Appeal Decision

Appeal Ref: APP/R5510/D/24/3341999

18 & 20 Wilmar Close, Hayes UB4 8ET

PROPOSED GROUND (H/18+20) FLOORPLAN

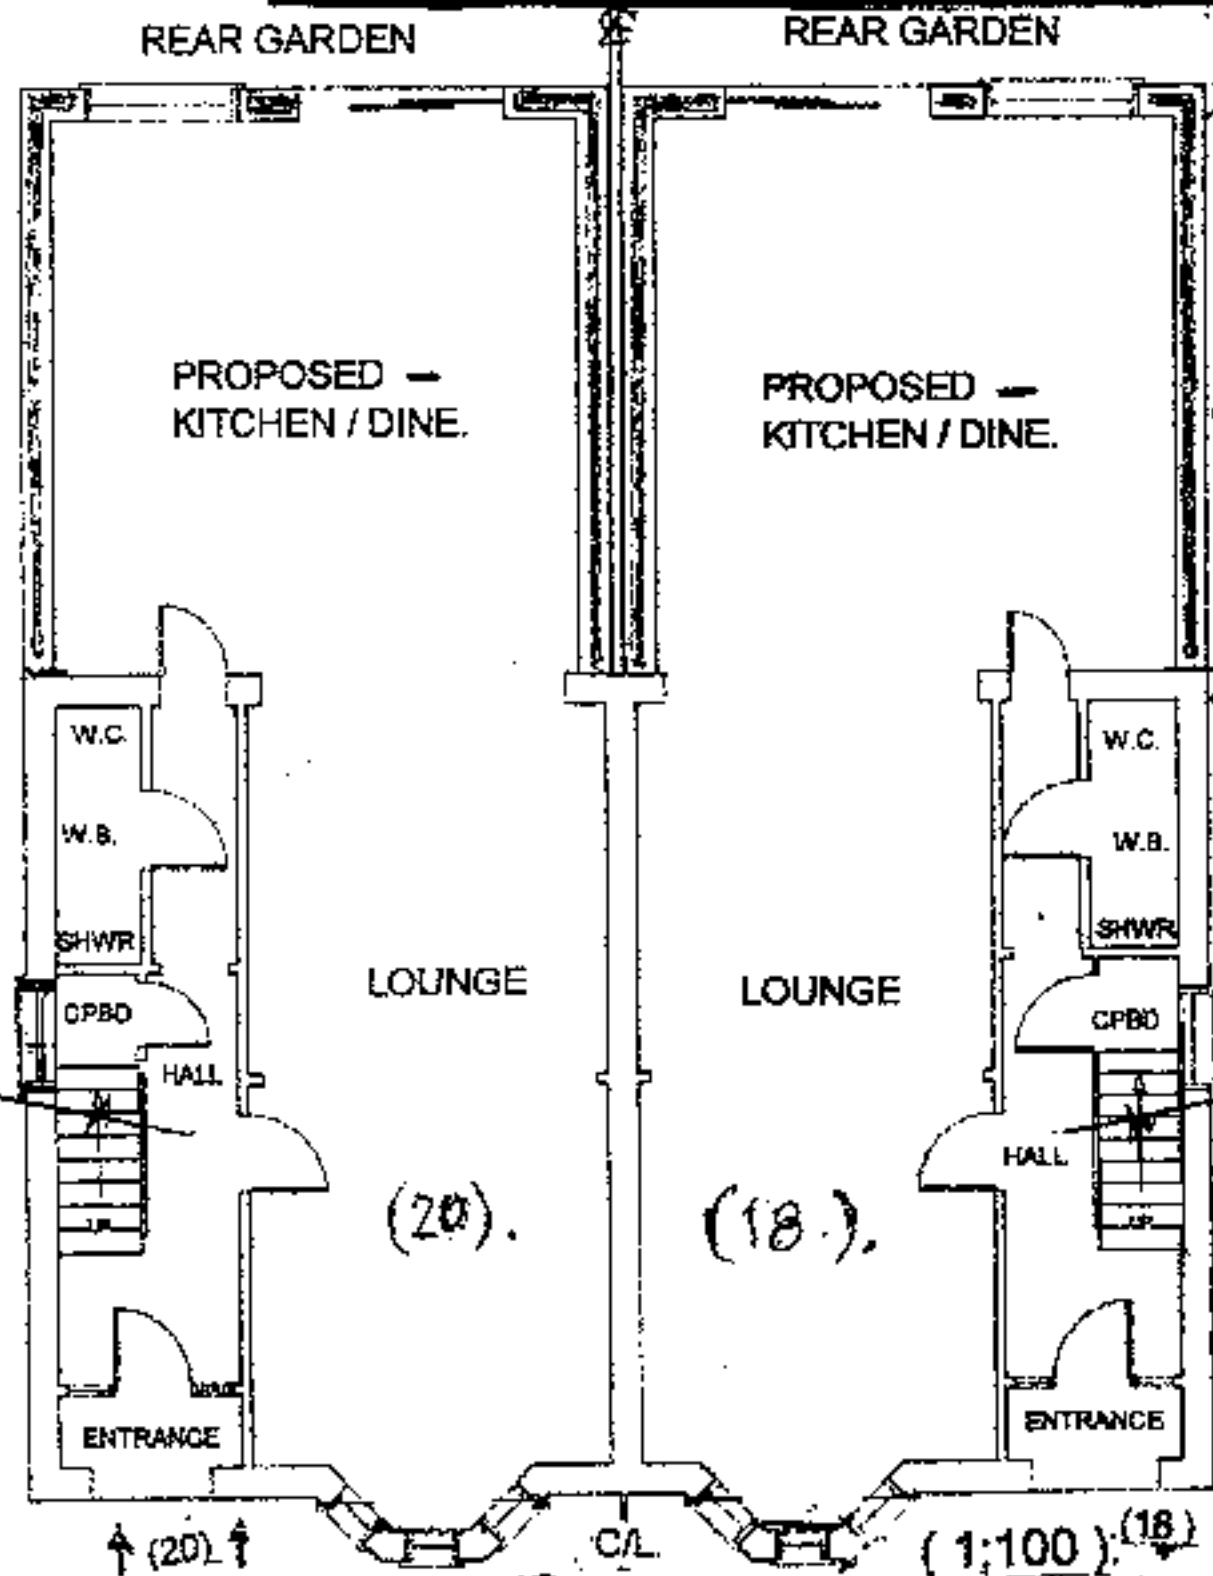
6. However, despite these favourable factors, I give significant weight to the Council's assessment that the visual impact of these matching two-storey extensions would be too radical. The full width ground floor of a 6m depth and its flat roof wraparound of the walls of the first floor additions would be an incongruous feature at odds with the simple form of the original dwellings, particularly because as a physically linked addition to two dwellings it would be perceived as being of a considerable size.

PROPOSED SIDE (H/20) ELEVATION, (1:100).

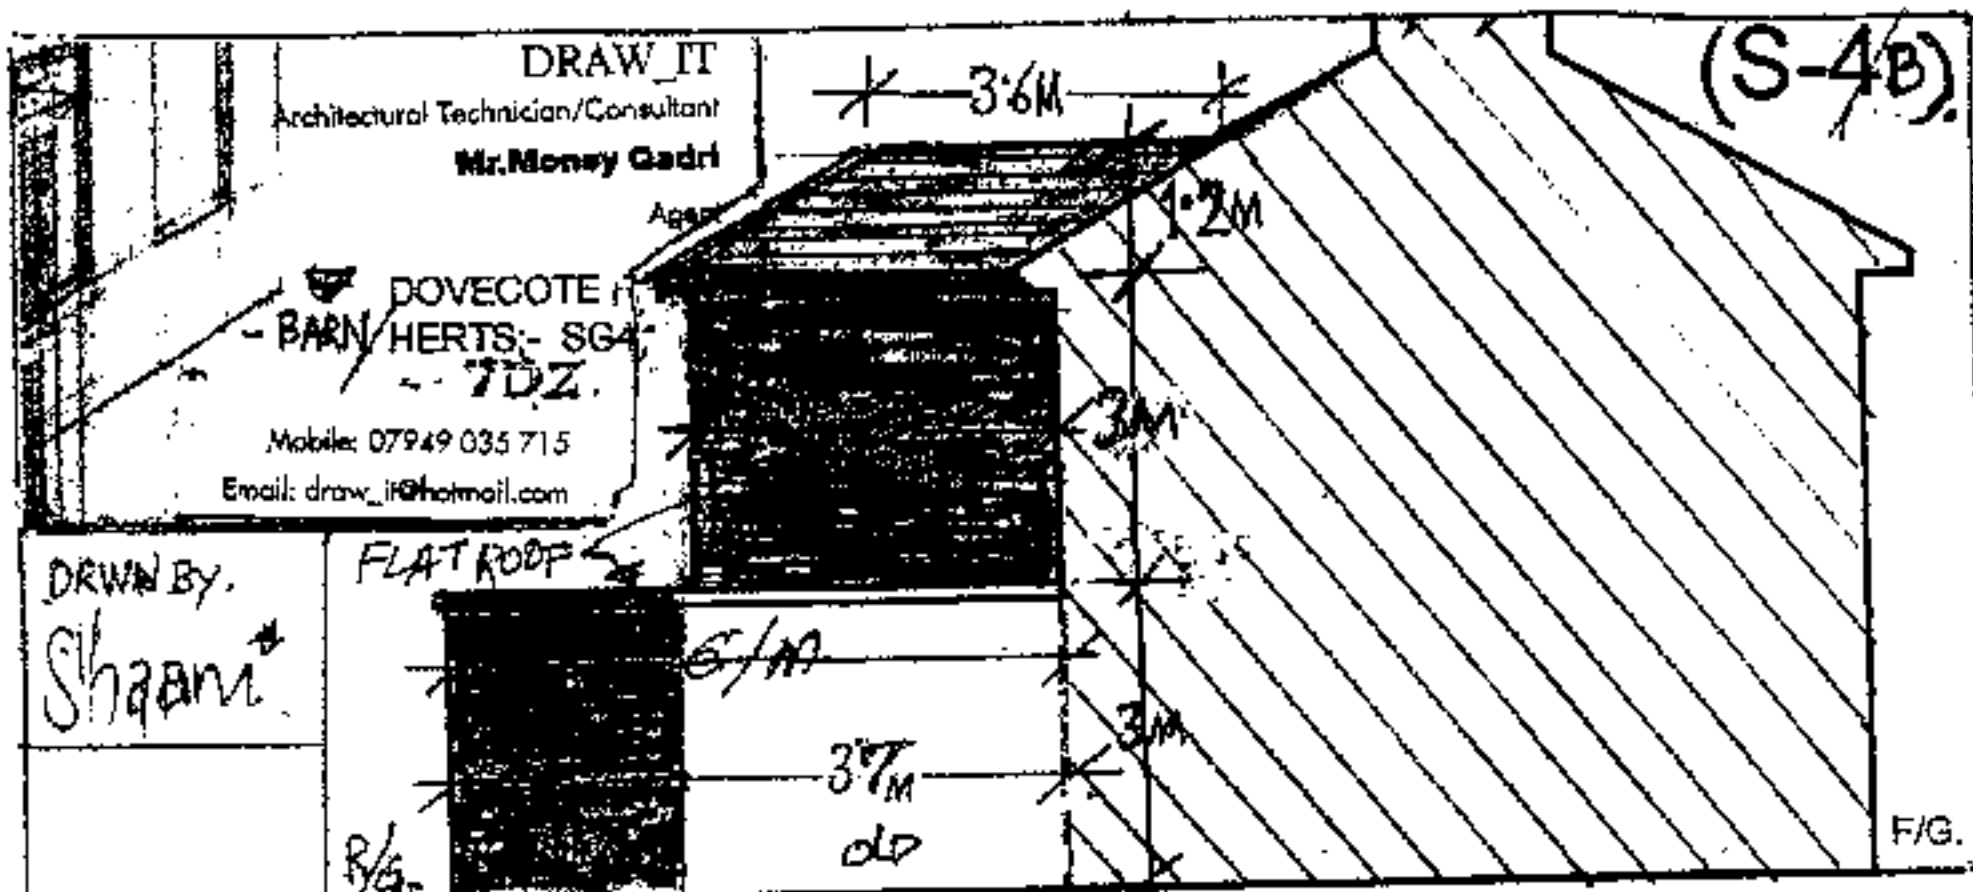
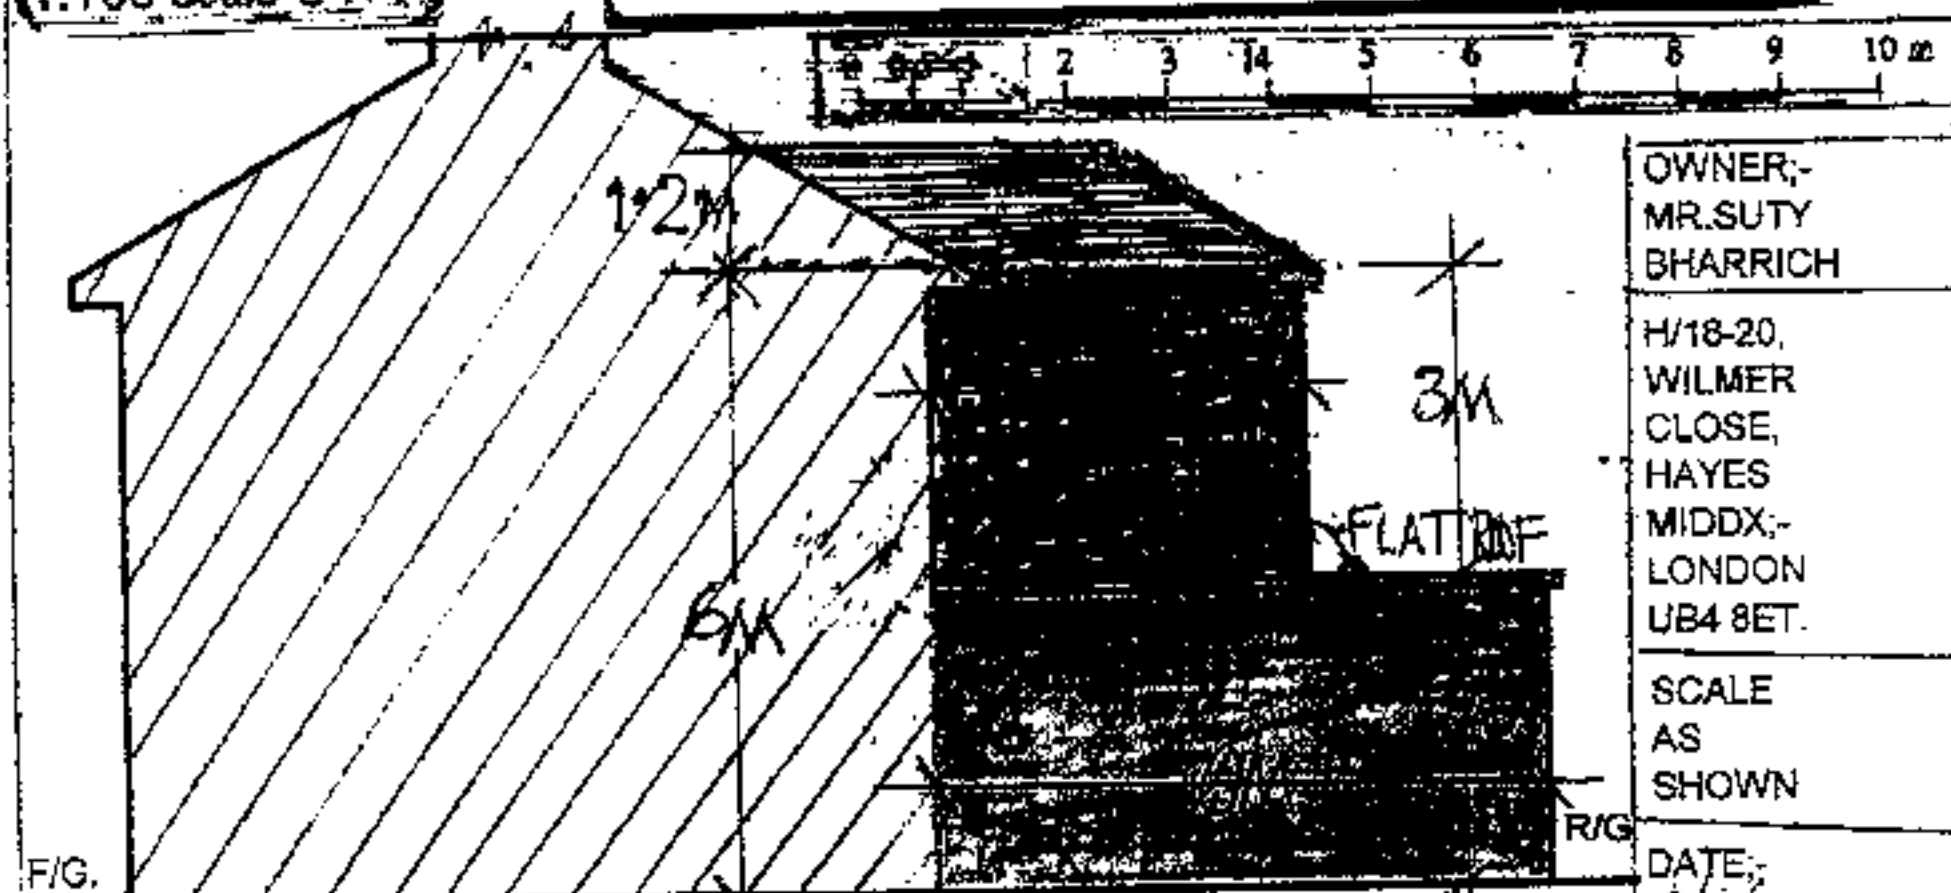
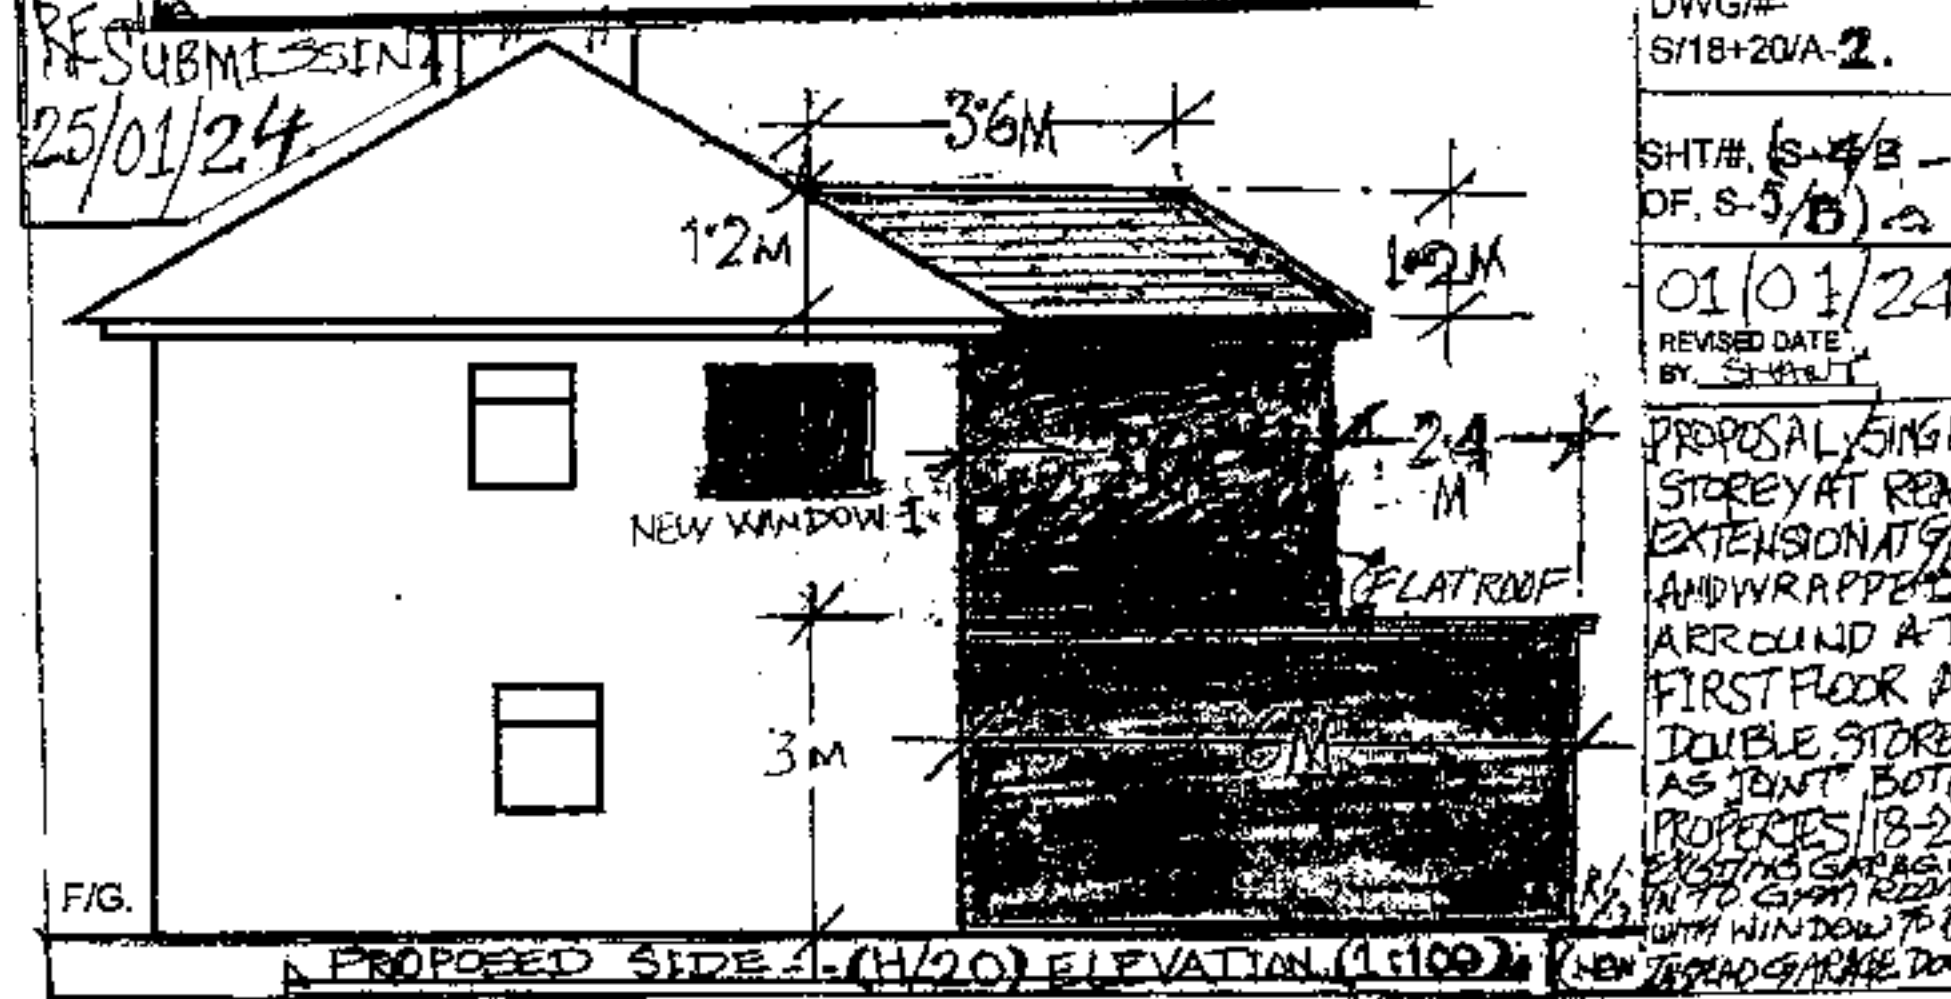
9. Turning to the second issue, the proposed bedroom 2 in each dwelling is considered by the Council to have inadequate outlook and natural light. The Officer's Report explains that a side window in each bedroom 2 is now proposed to overcome the similar inadequacies of the rooflights proposed in previously refused application ref. 78150/APP/2023/2276.

10. However, it is clear from both the submitted plans and my site inspection that these windows would need to be obscure glazed and non-opening up to 1.7m above internal floor levels to prevent the overlooking of the more private areas of Nos. 19 and 16 Wilmar Close. And in so doing, this would preclude the outlook from the bedrooms and restrict natural light to them, resulting in unacceptable living conditions for the occupiers. I acknowledge that the relatively large size of the windows would be helpful in terms of light, but conversely this would be harmful as regards the increased potential for overlooking and a resulting need for obscure glazing to safeguard neighbours' privacy.
